From: Ron Bohannon [rrb@tierrawestllc.com]
Sent: Wednesday, August 03, 2011 11:30 AM
To: Cherne, Curtis
Subject: RE: 2417 Aztec

Re: Aztec LLC Office/ Warehouse, 2417 Aztec Rd. NE, (G-16/D027)

Re: Aztec LLC Warehouse/Office, 2417 Aztec RD NE
Grading and Paving Plan
Engineer's Stamp dated 3-29-07 (G16/D027)

Re: Aztec LLC Warehouse/Office, 2417 Aztec RD NE
Grading and Paving Plan
Engineer's Stamp dated 3-14-07 (G16/D027)

SHEET NO. 2 OF 2
CD
RECEIVED
JUL 22 2011
HYDROLOGY SECTION

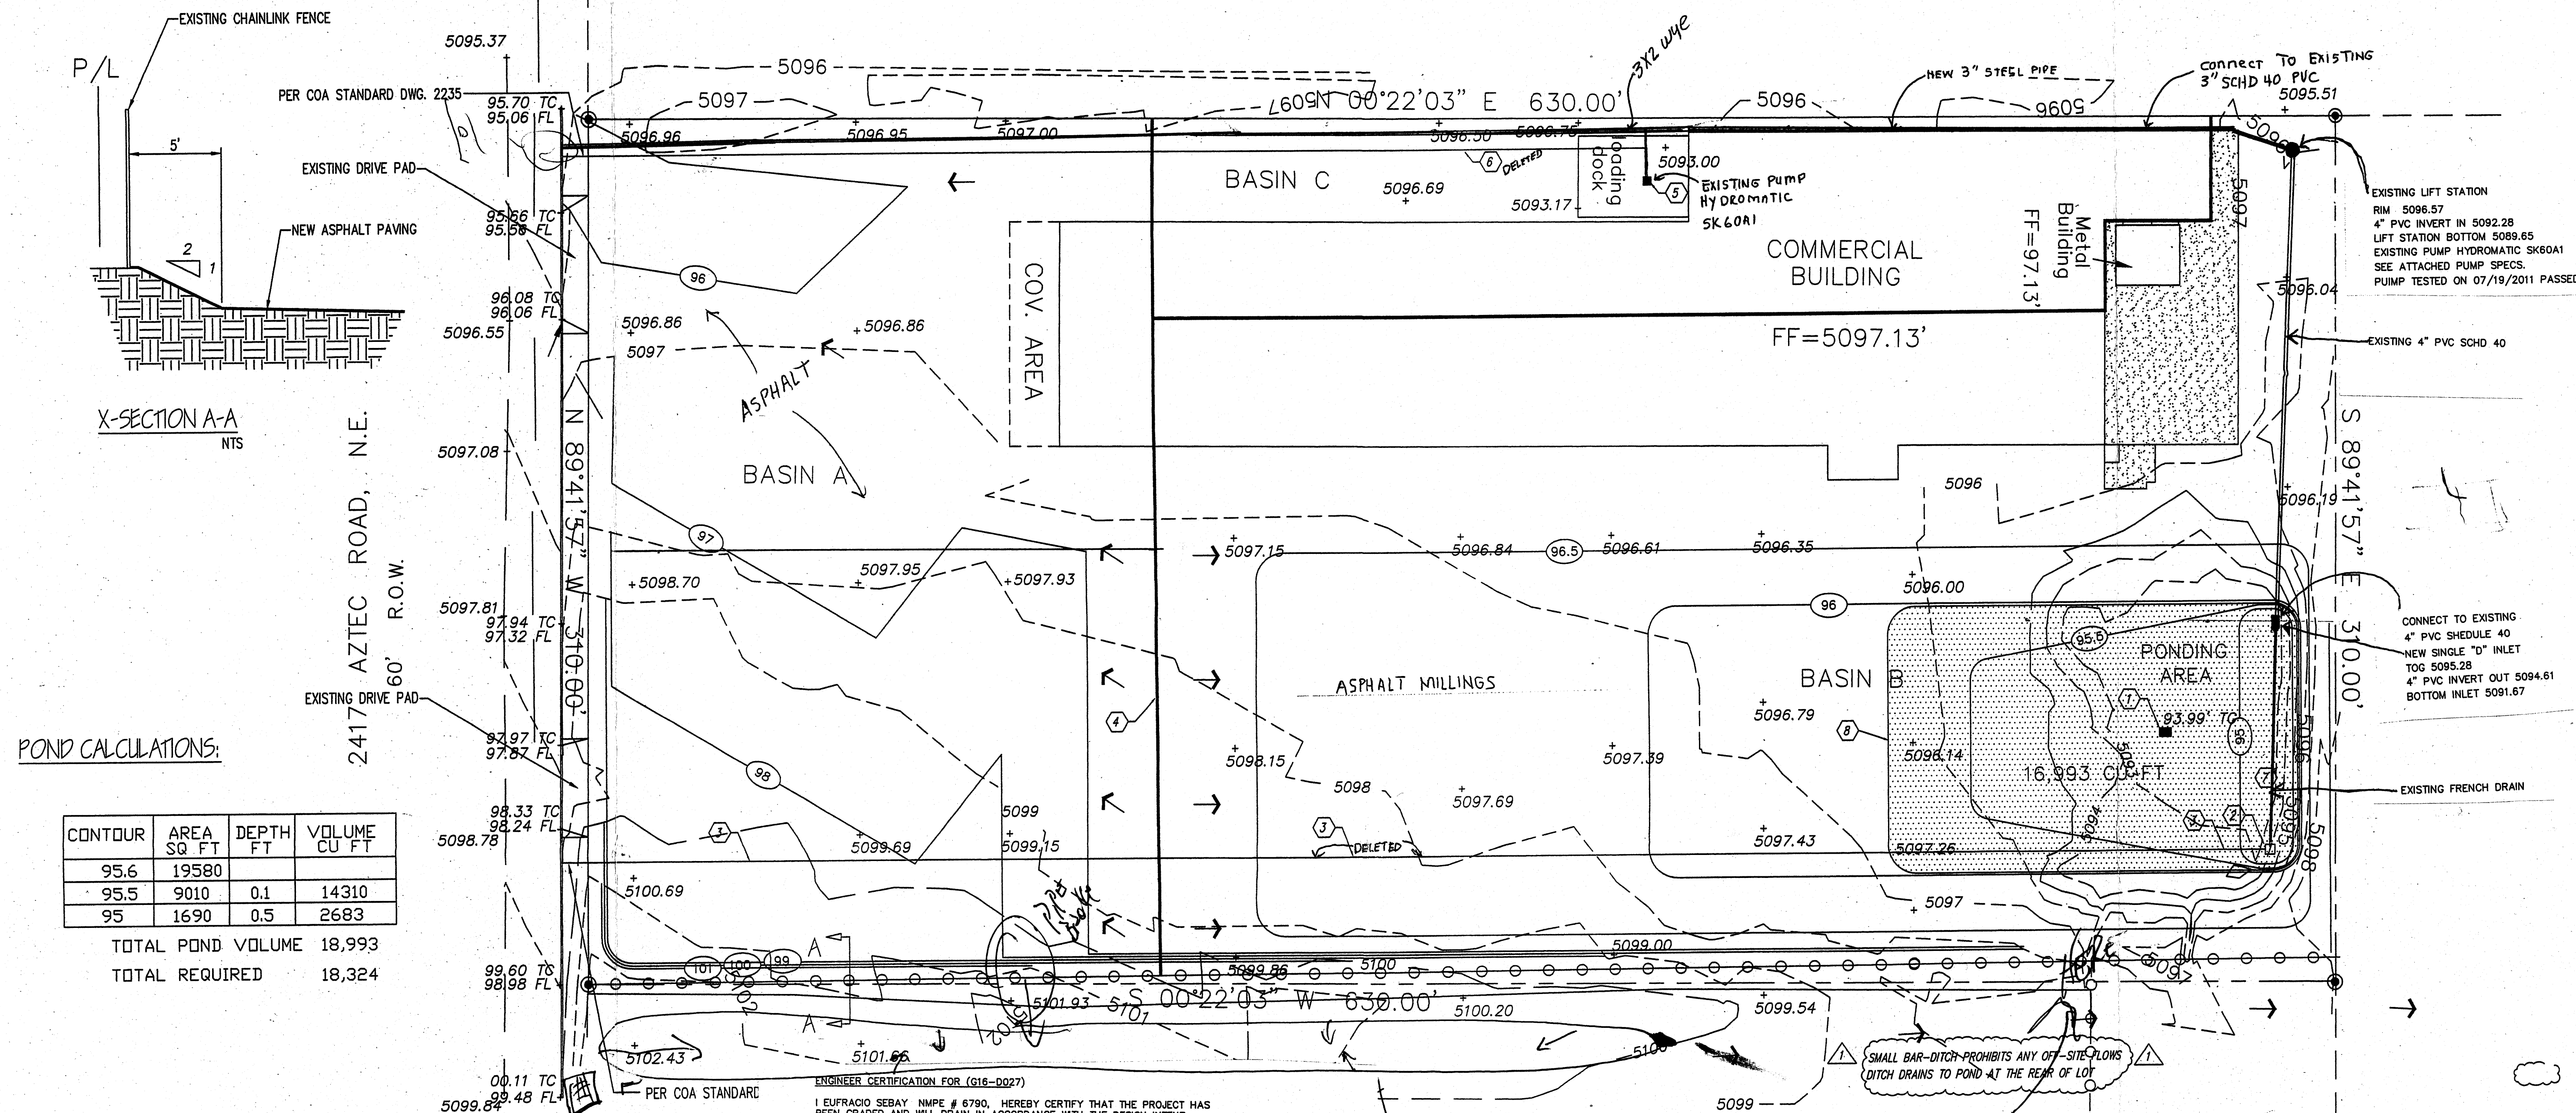
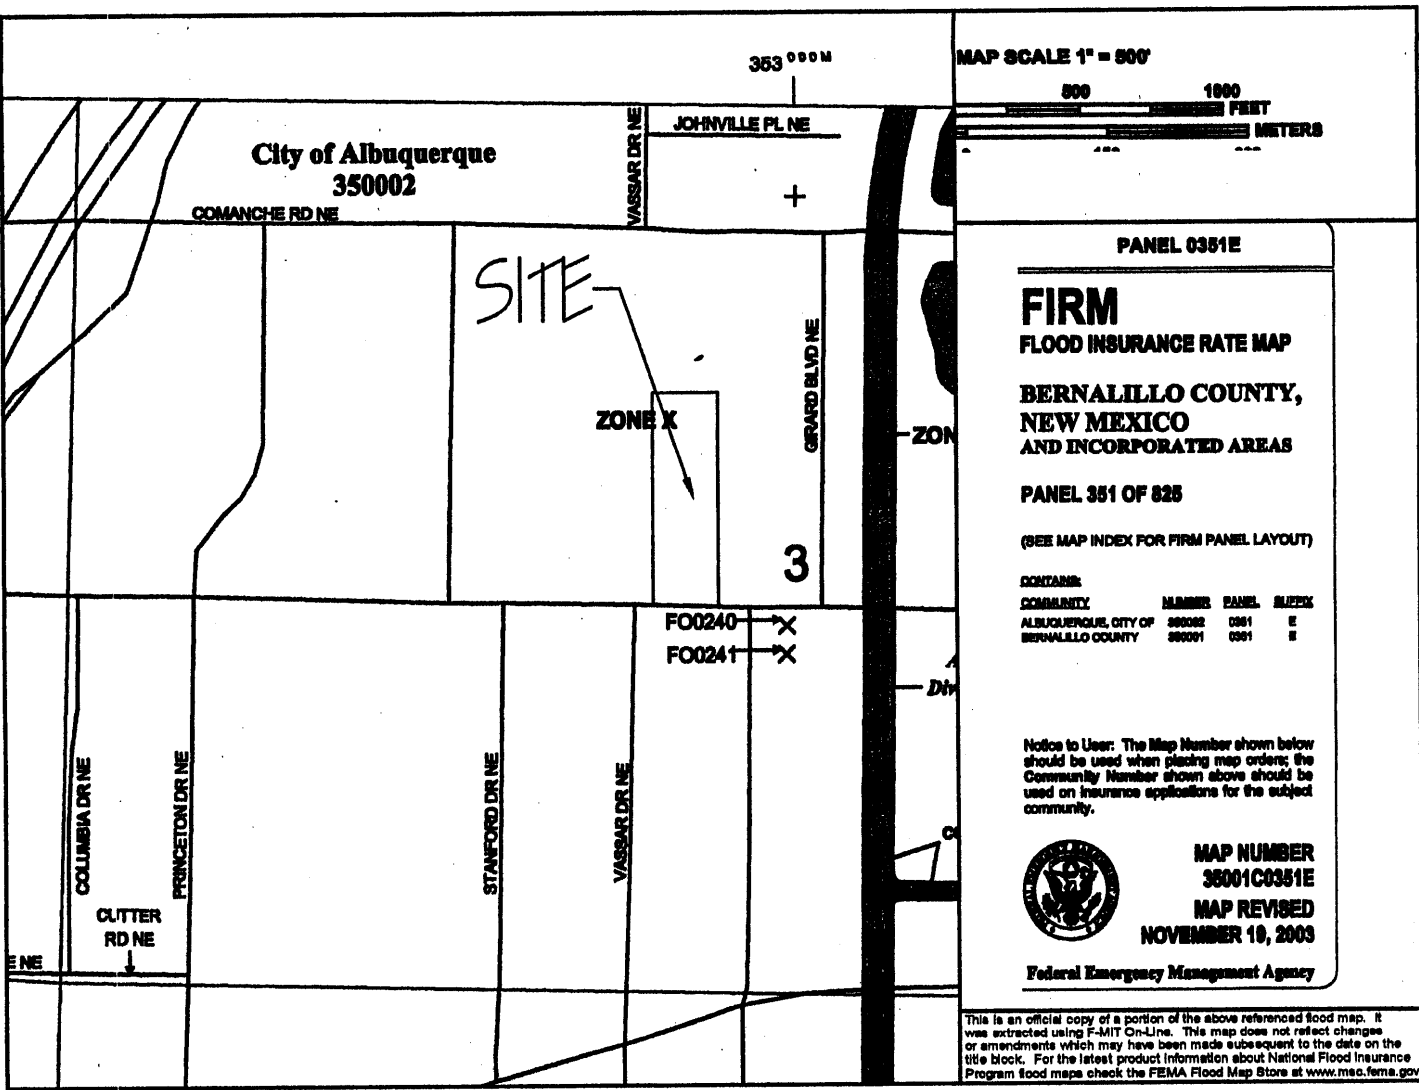
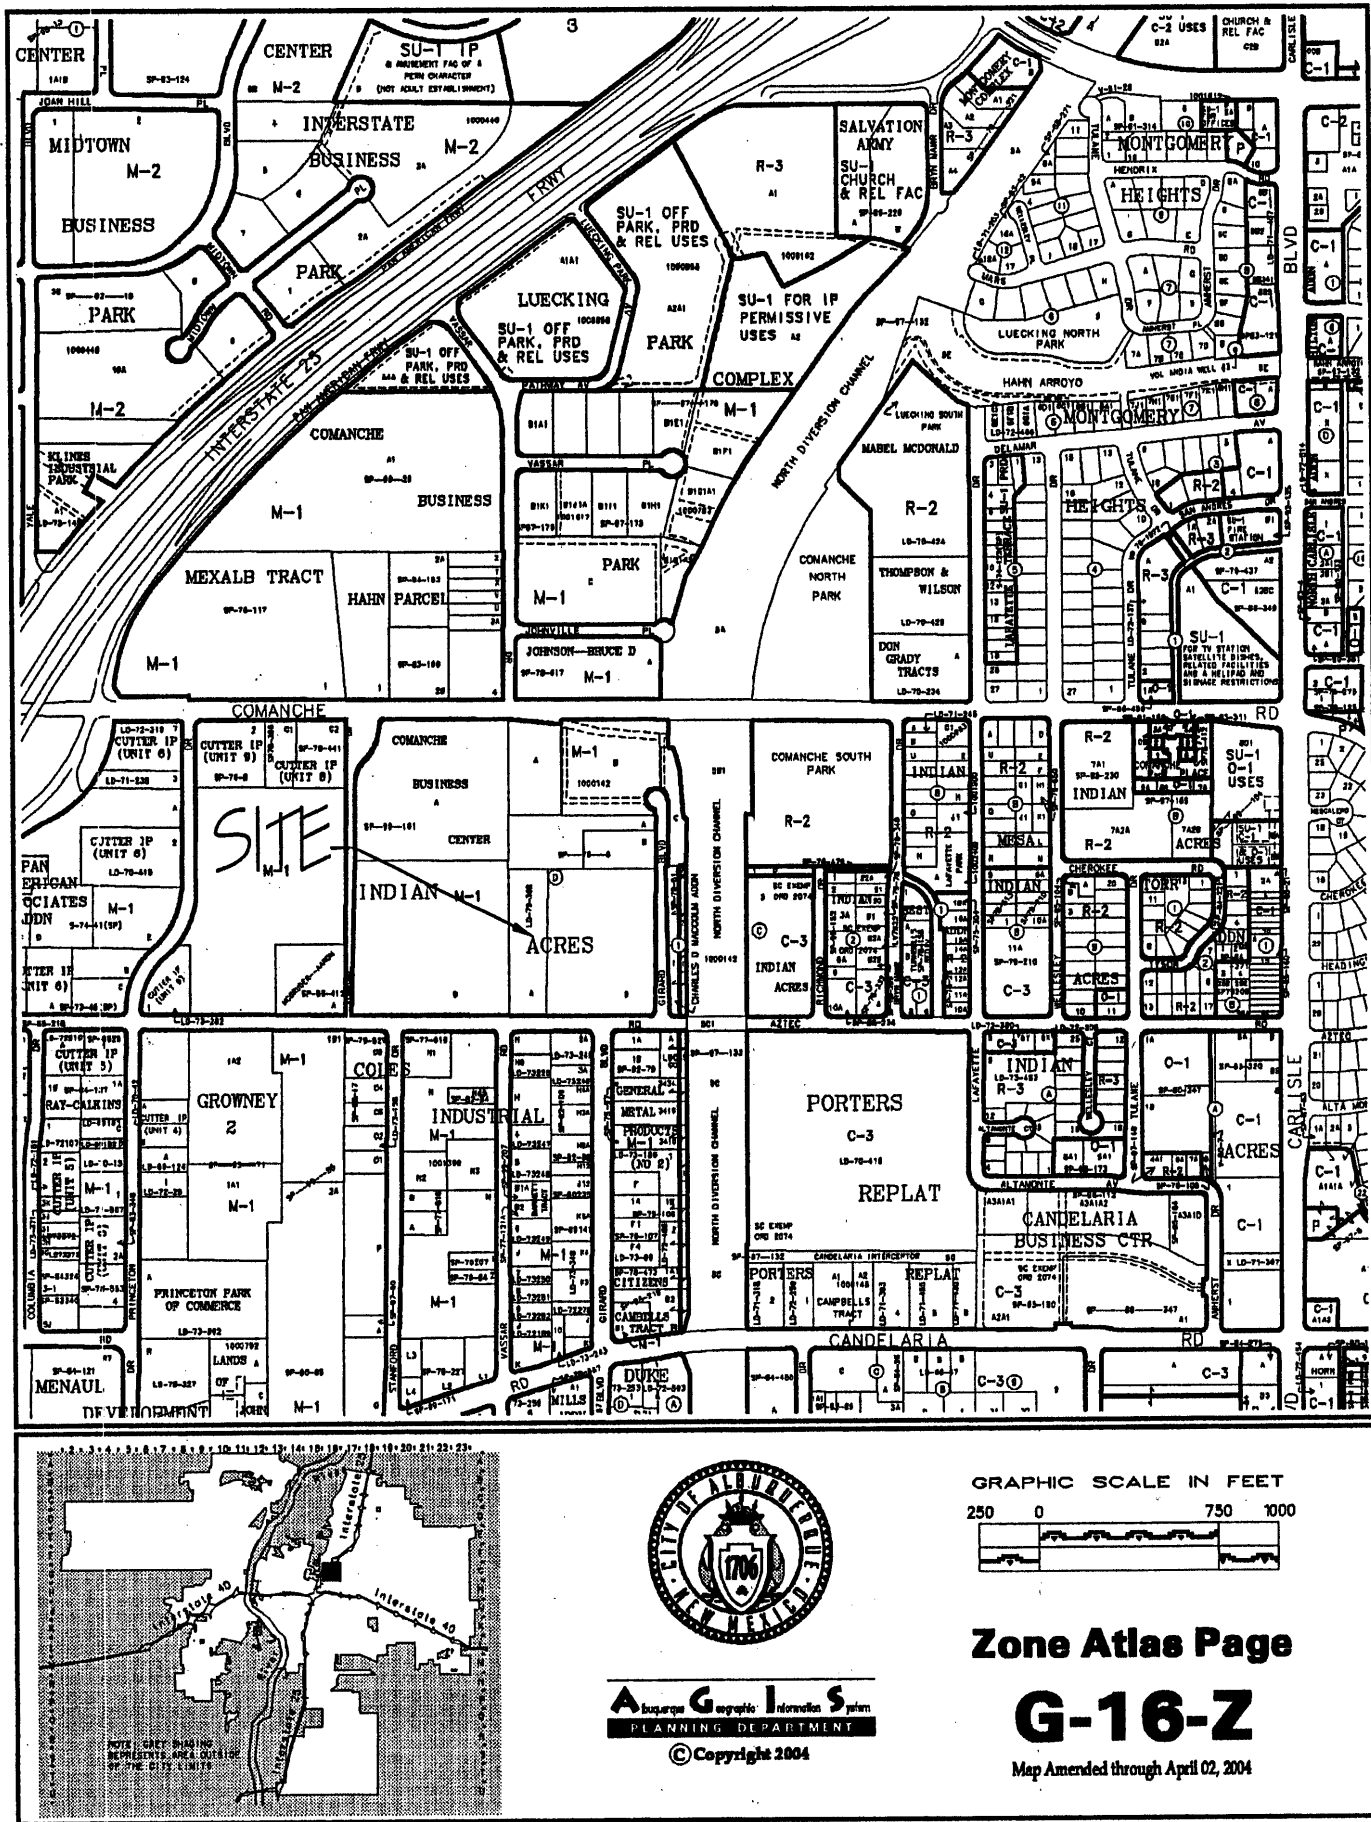
Curtis what was certified was not what we had found in the file for approval. The plan that is approved that we could find has two lift stations one running down each property line. What is in the field is one lift station running along the west side of the property?
